Demolition of existing single storey side extension and construction of an attached two storey self contained dwelling.

> From: Fiona Rae <FRae@hillingdon.gov.uk>
> Date: 11 October 2022 at 17:39:15 BST
> To: enquiries@greystokebuilders.com
> Cc: Katie Crosbie <KCrosbie@hillingdon.gov.uk>
> Subject: 2 Worcester Rd

> Please can you ask your agent to re-submit the application with the access issues resolved. What we need to address are:

GROUND FLOOR PLAN

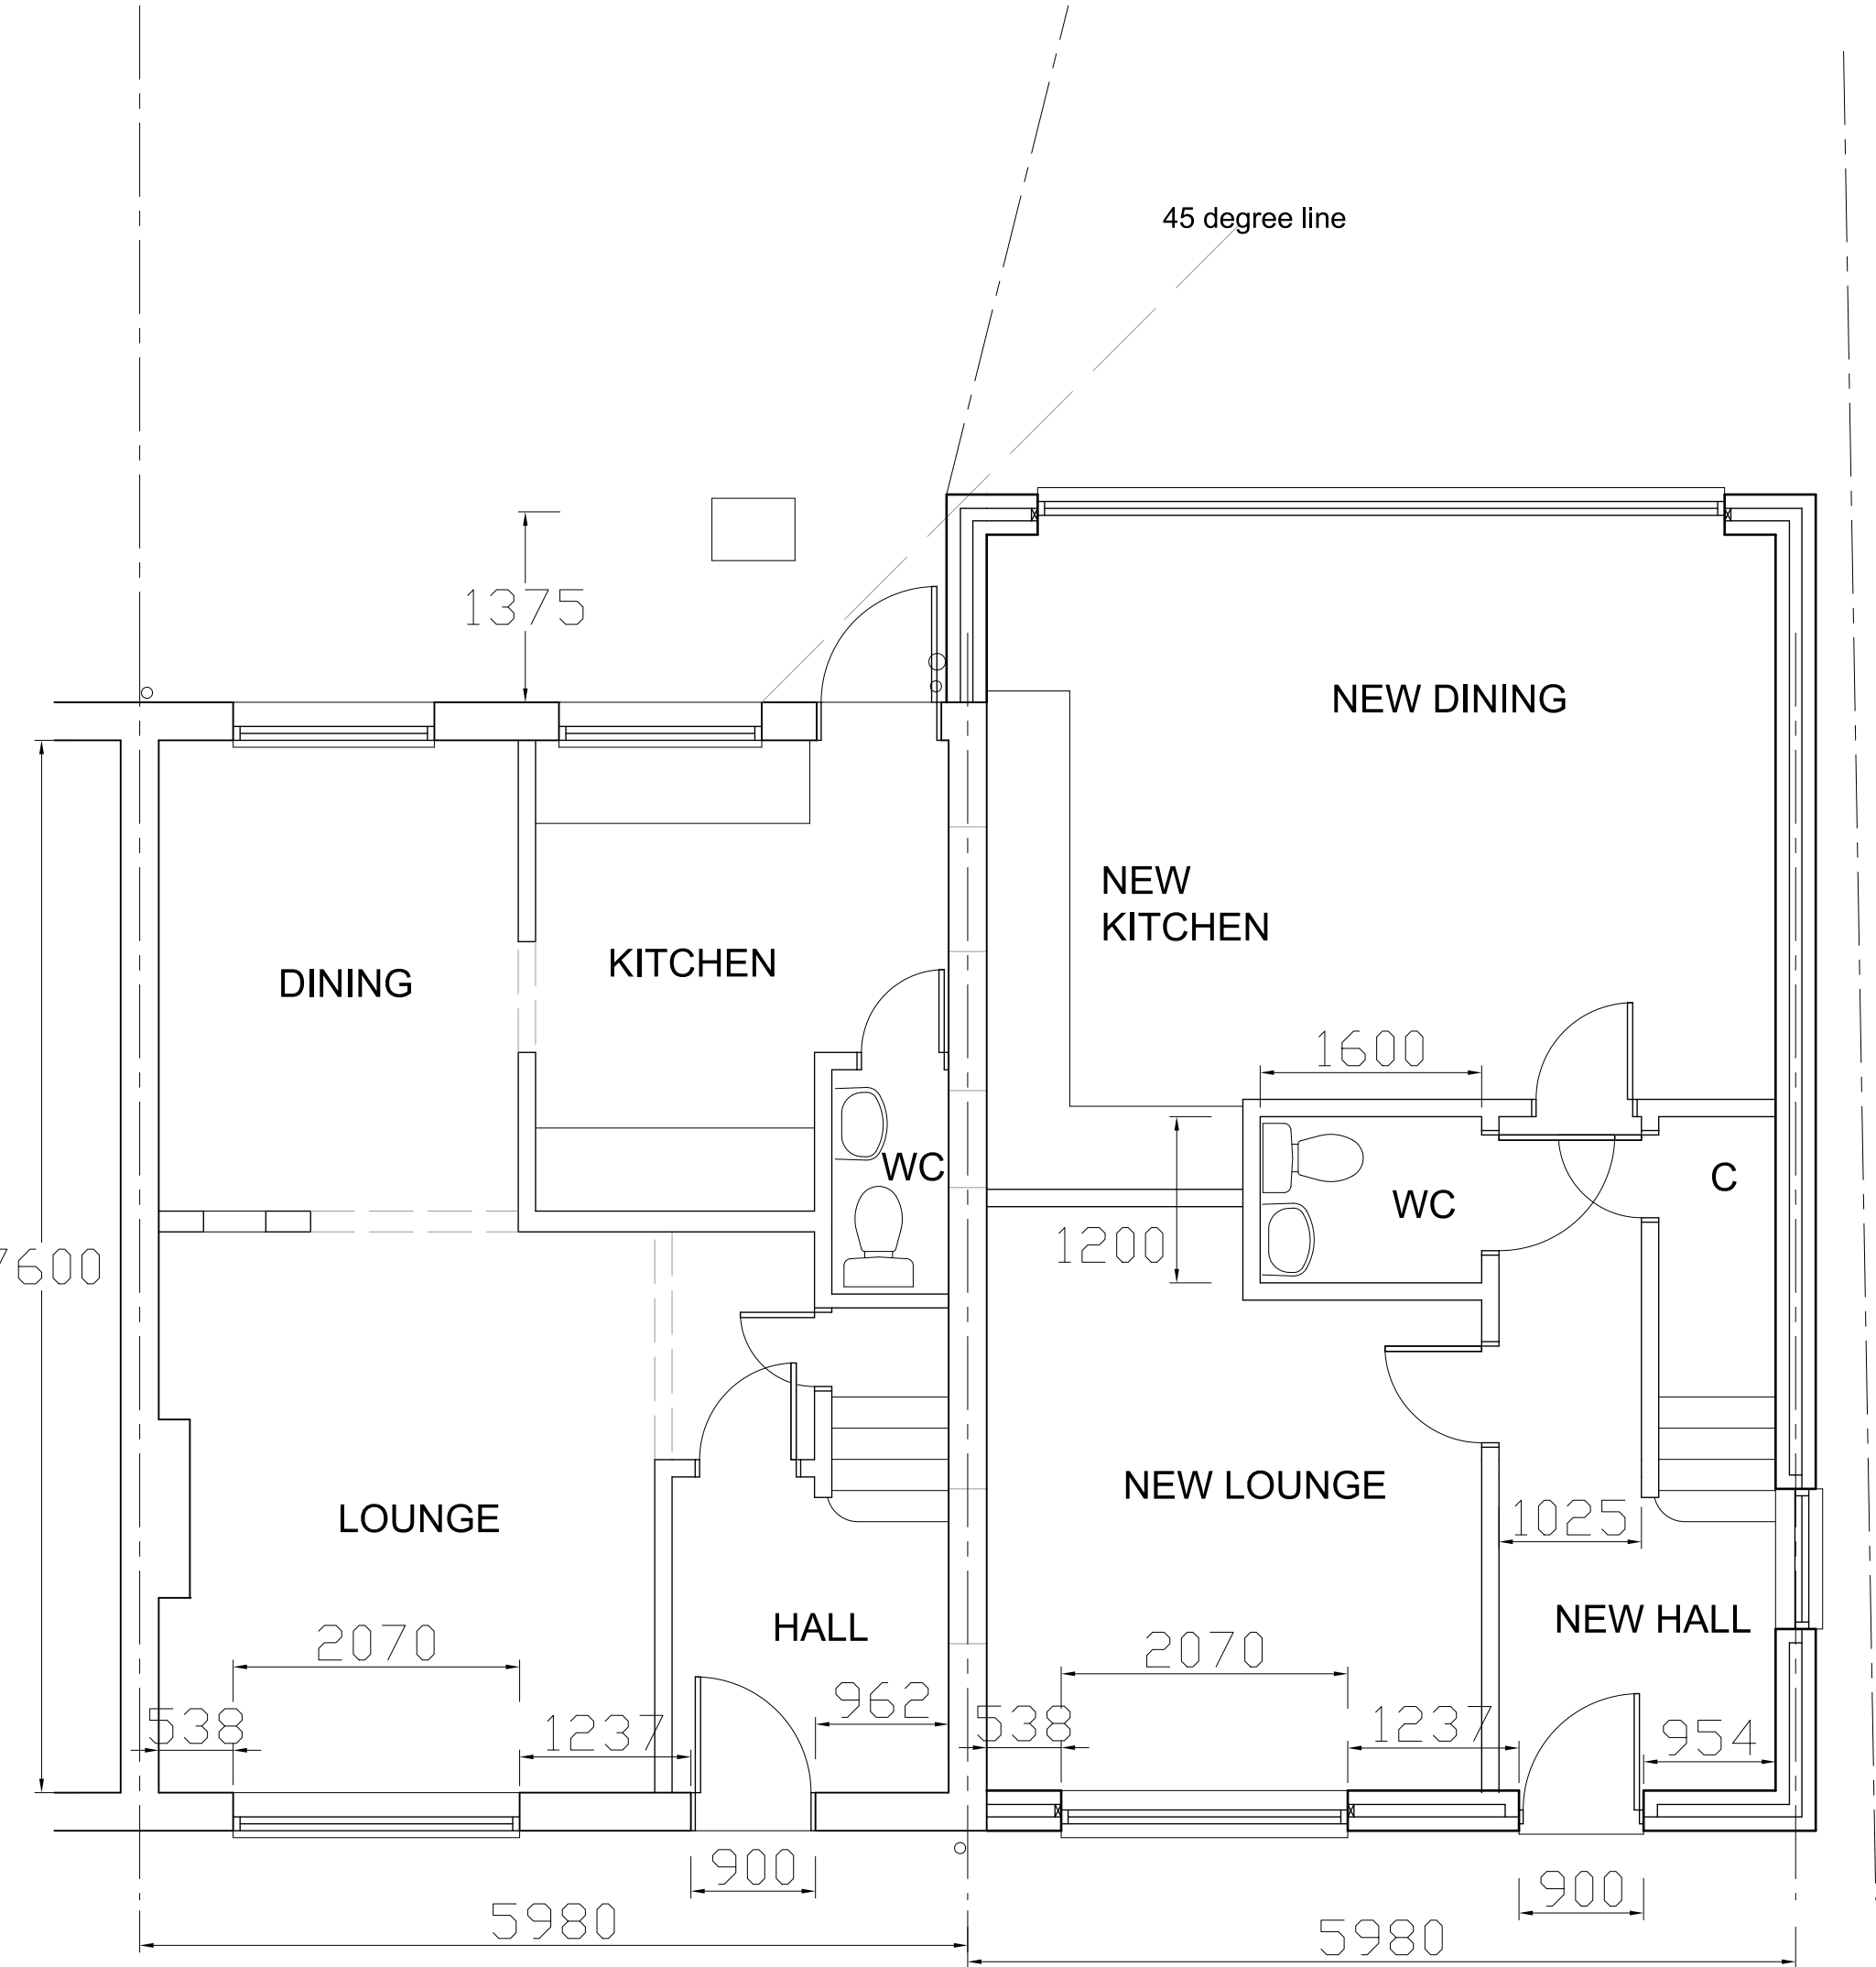
> 2. The entrance level plan does not show an entrance level WC. A suitably sized and designed cubicle should be shown on plan to meet the provisions set out in section 2.27(c) of Approved Document M, volume 1 (2015 edition).

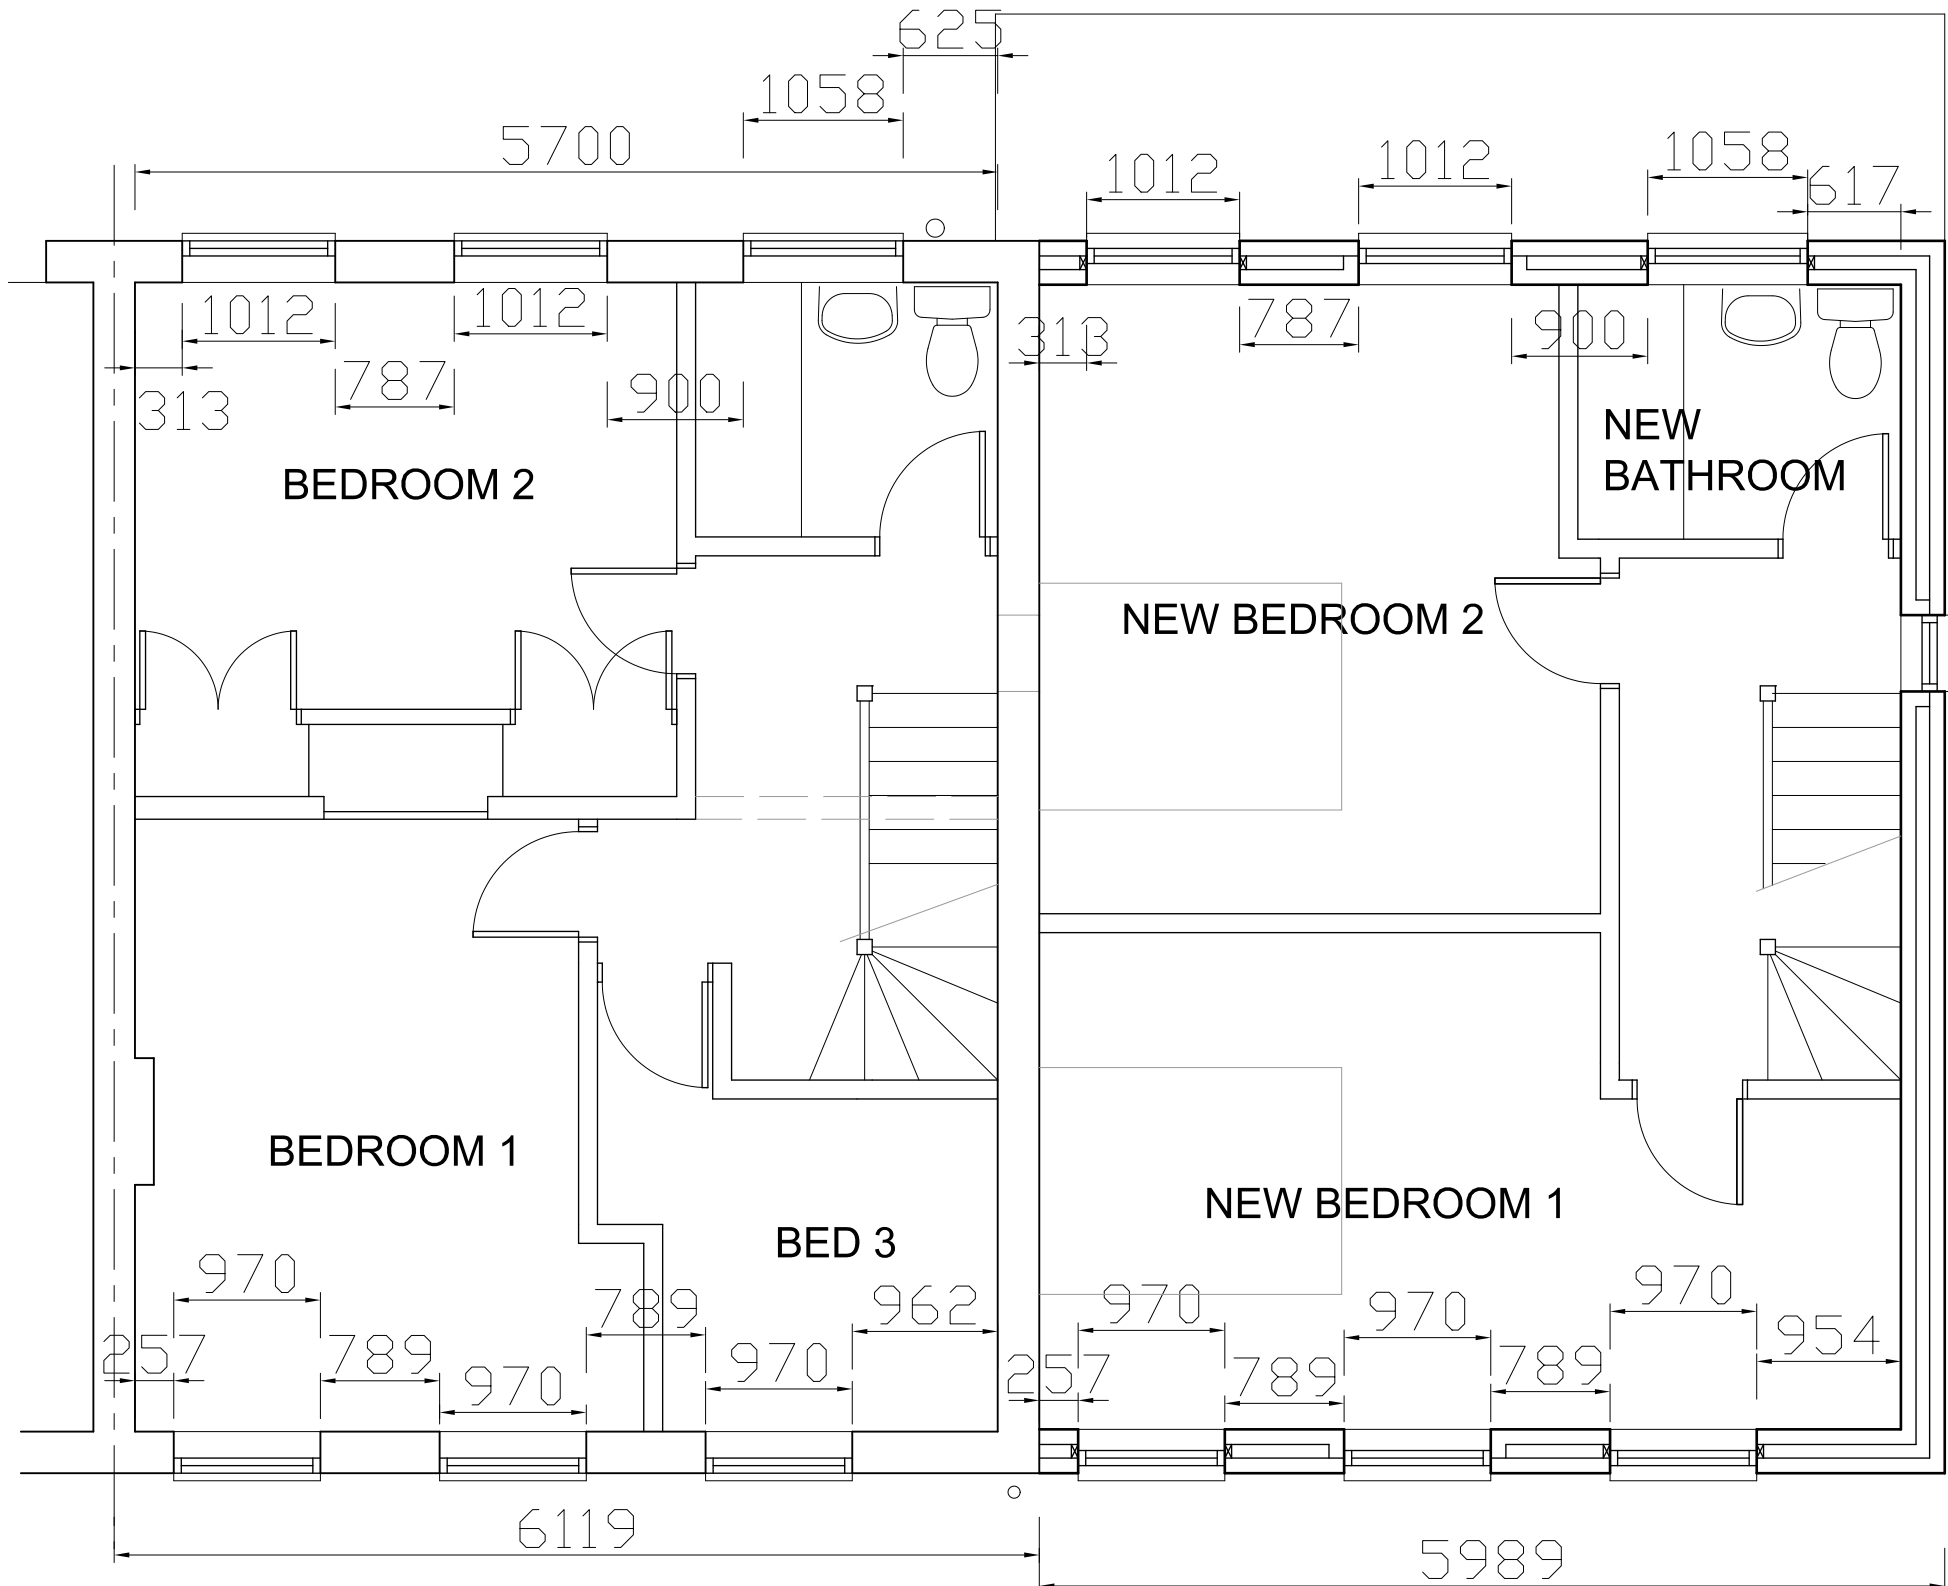
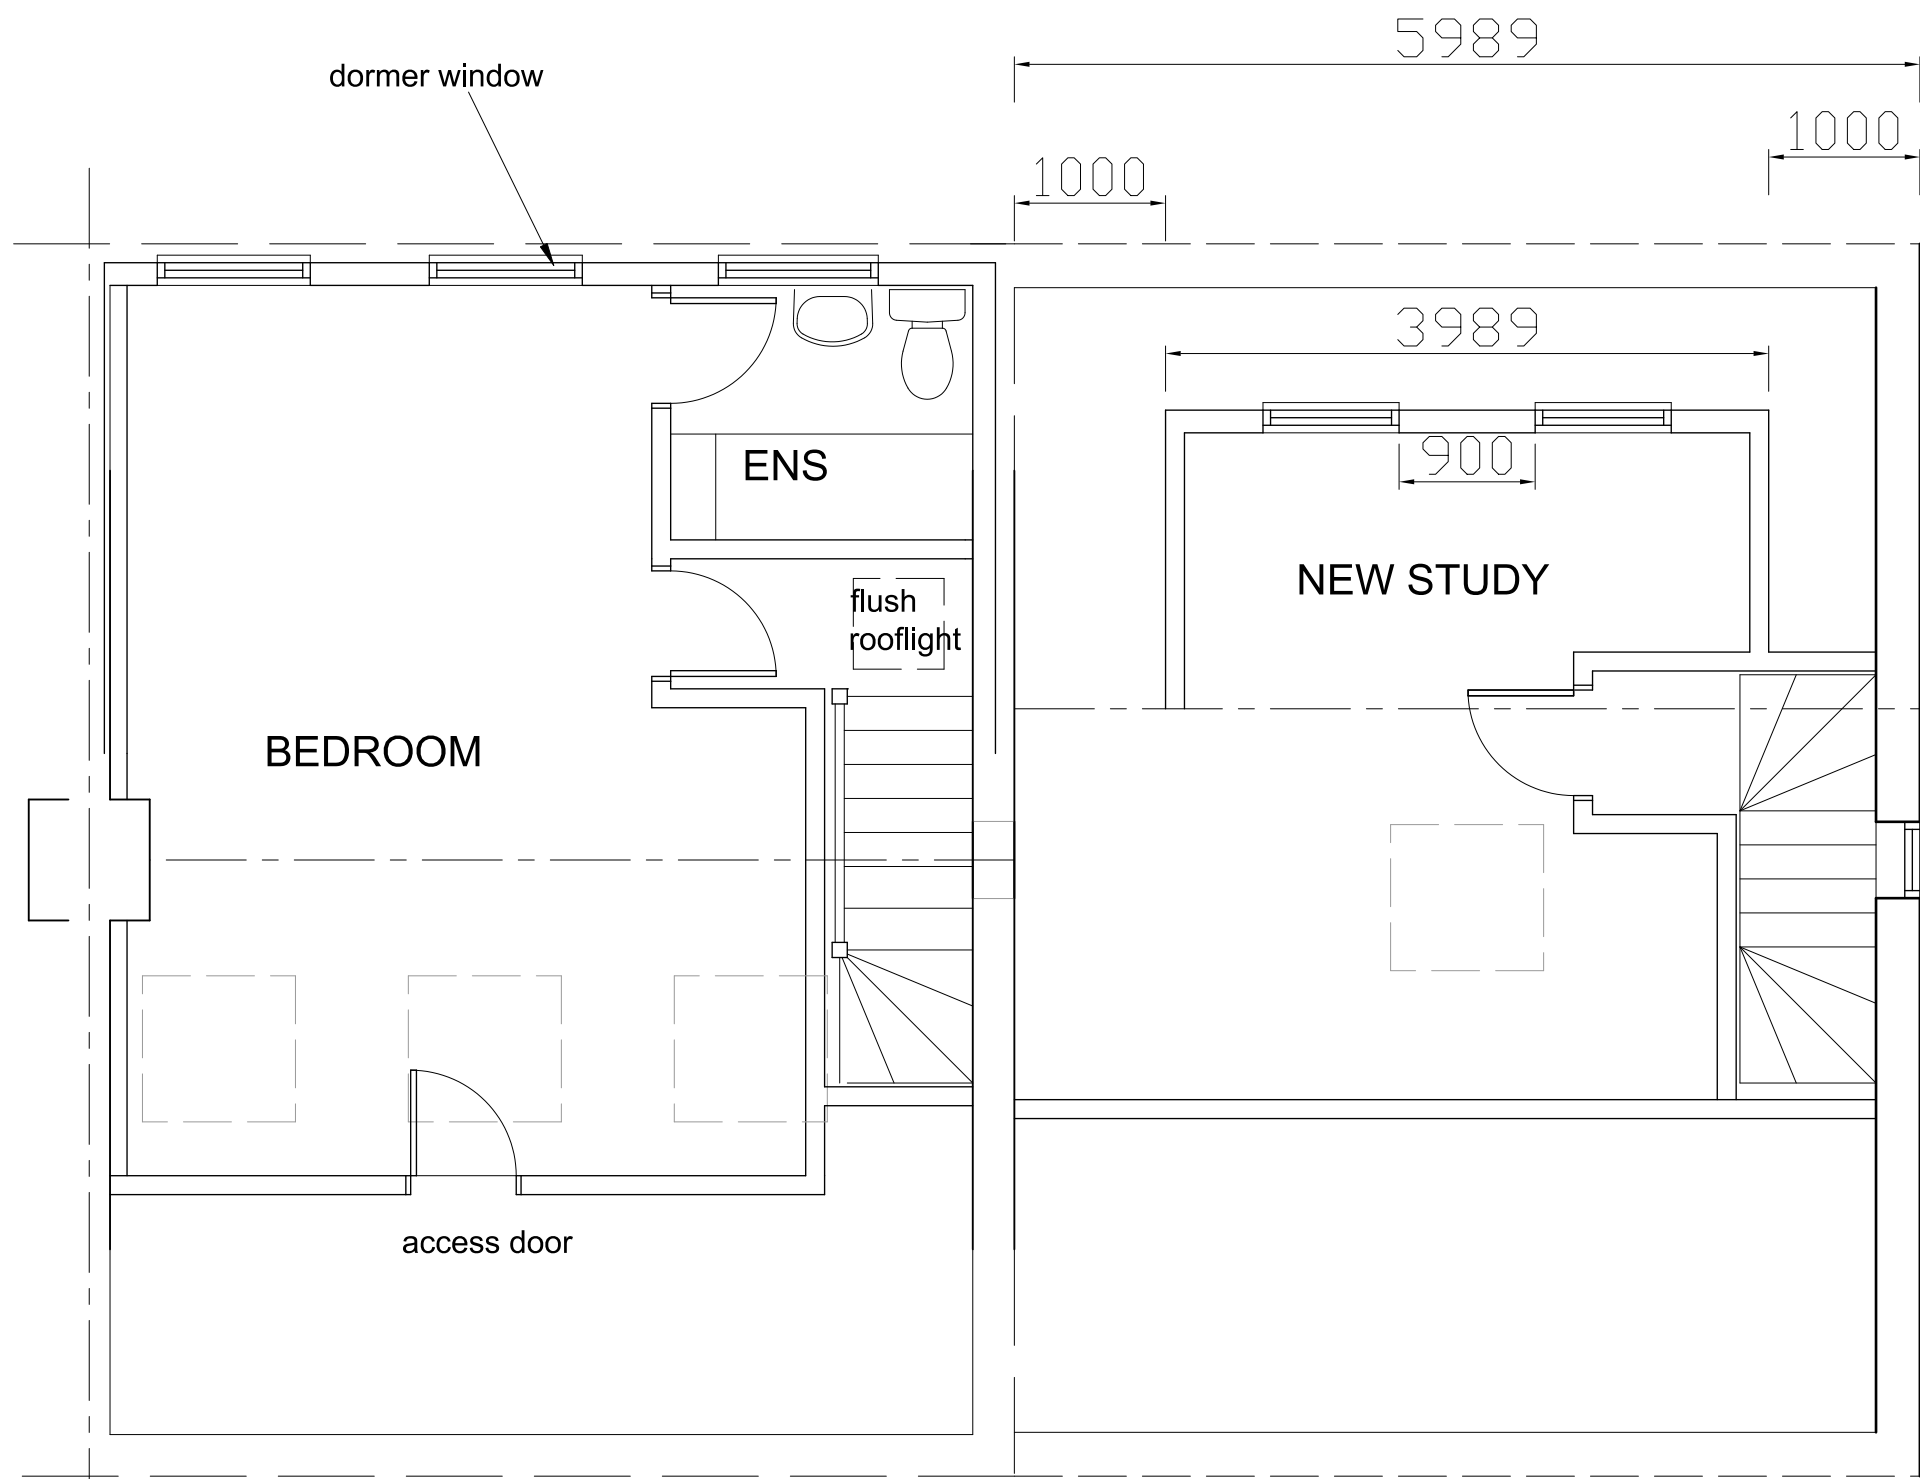
> 3. Particular attention should also be paid to the entrance lobby arrangement and to spatial requirements within the bedrooms, bathrooms and kitchen area. The plans should be amended accordingly to demonstrate compliance with the technical specifications within Approved Document M to the Building Regulations (2015 edition).
